Our Ref: 2016/137675  
File No: R/2010/580/G  
Your Ref: MP 10\_0048 MOD 8

**RE: Exhibition of Modification Request for Barangaroo Headland Park and Northern Cove Main Works, Barangaroo (MP 10\_0048 MOD 8) – Demolition of Harbour Control Tower**

Figure 3.1 - Site Layout Merriman Street Level

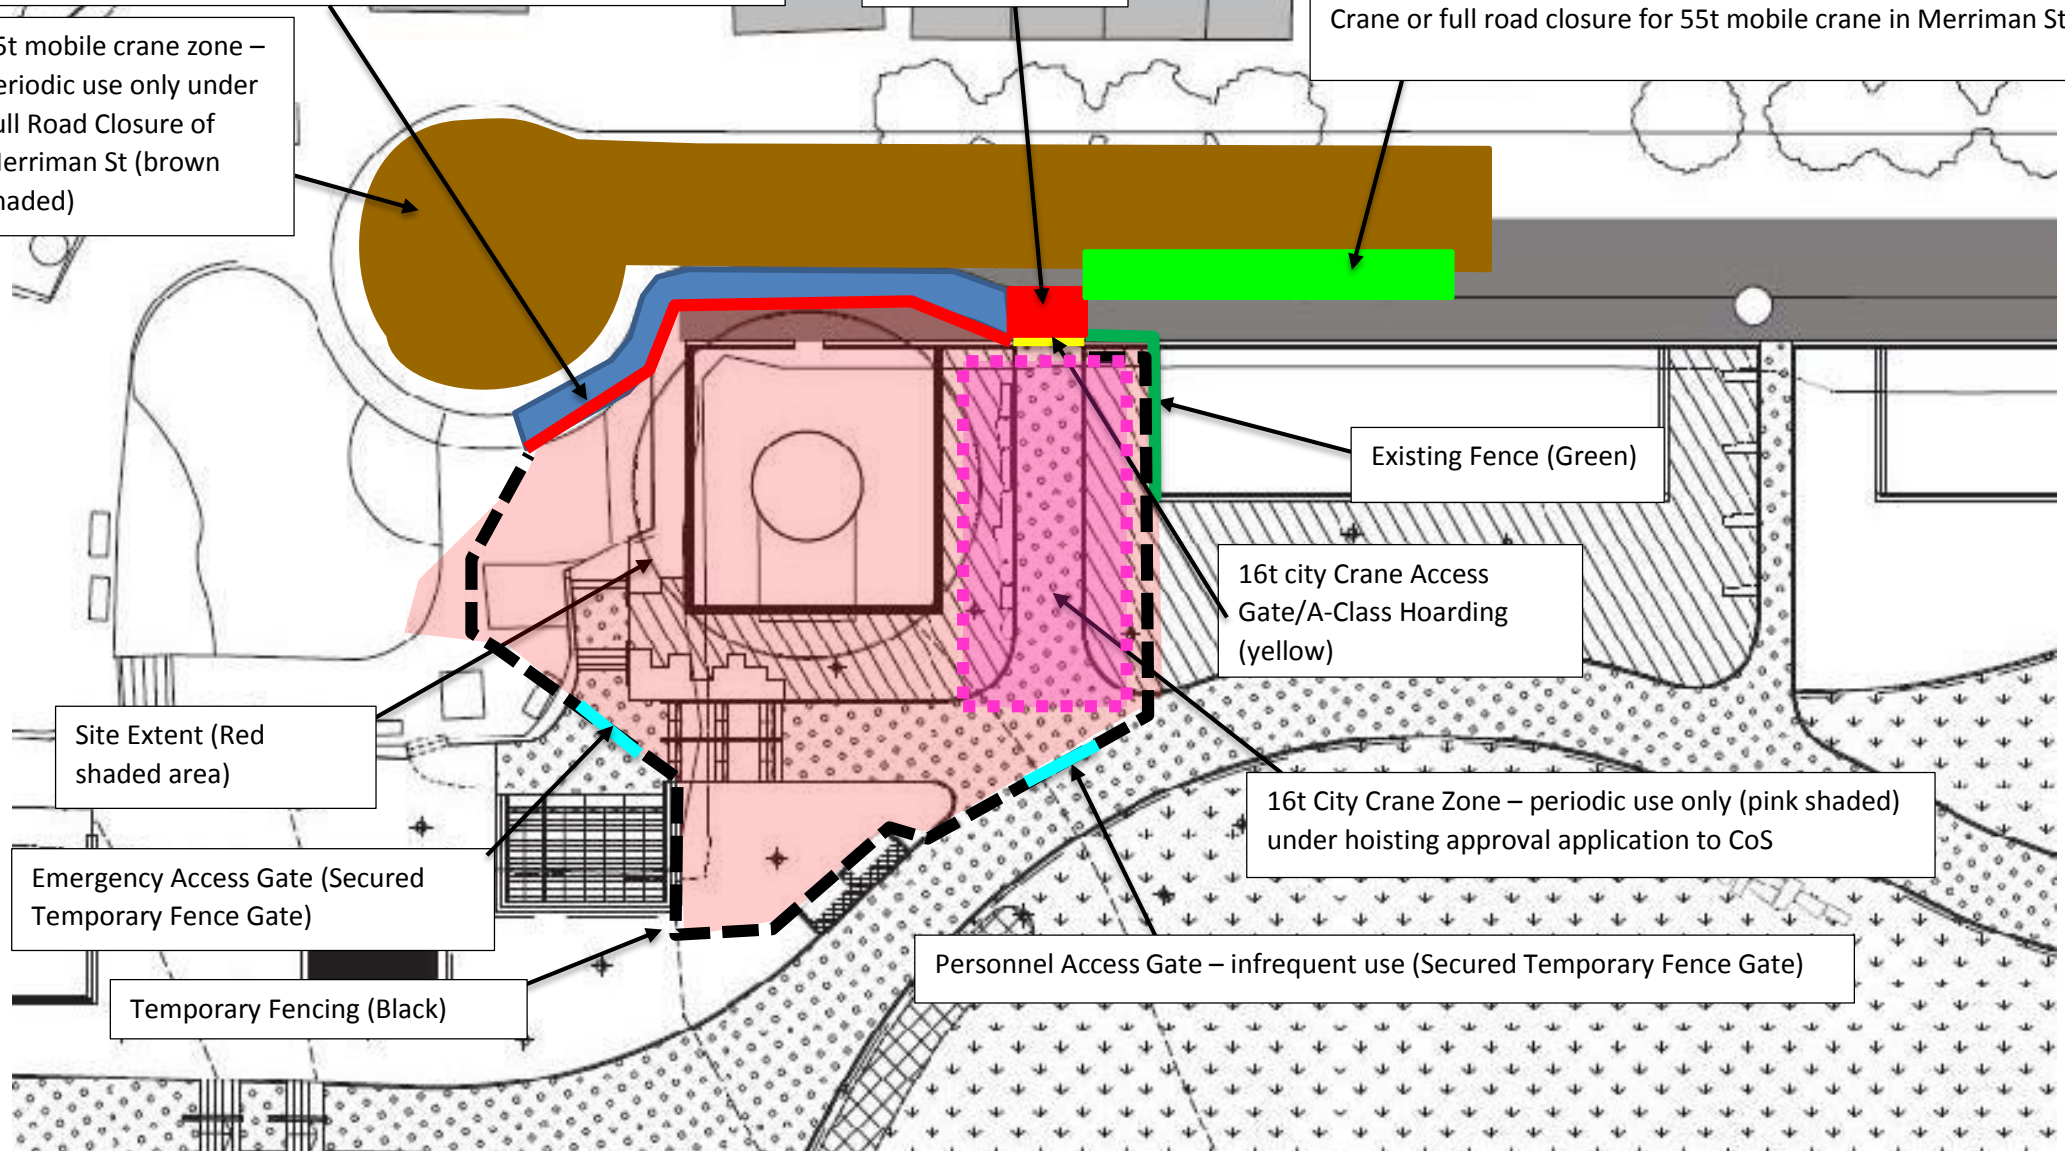
2. A Footpath Damage Bank Guarantee is required for the Tower demolition works.
3. The revised Demolition Work Statement requires cranes to be located on Merriman Street to facilitate the installation of the XL platform. The method will also require the erection of scaffold or hoarding along the western side of Merriman Street throughout the works period. While the revised demolition method will likely reduce the risk to the stone kerb and gutters along Merriman Street, the revised method does not eliminate these risks. As such, the City does not support the modification of this condition.
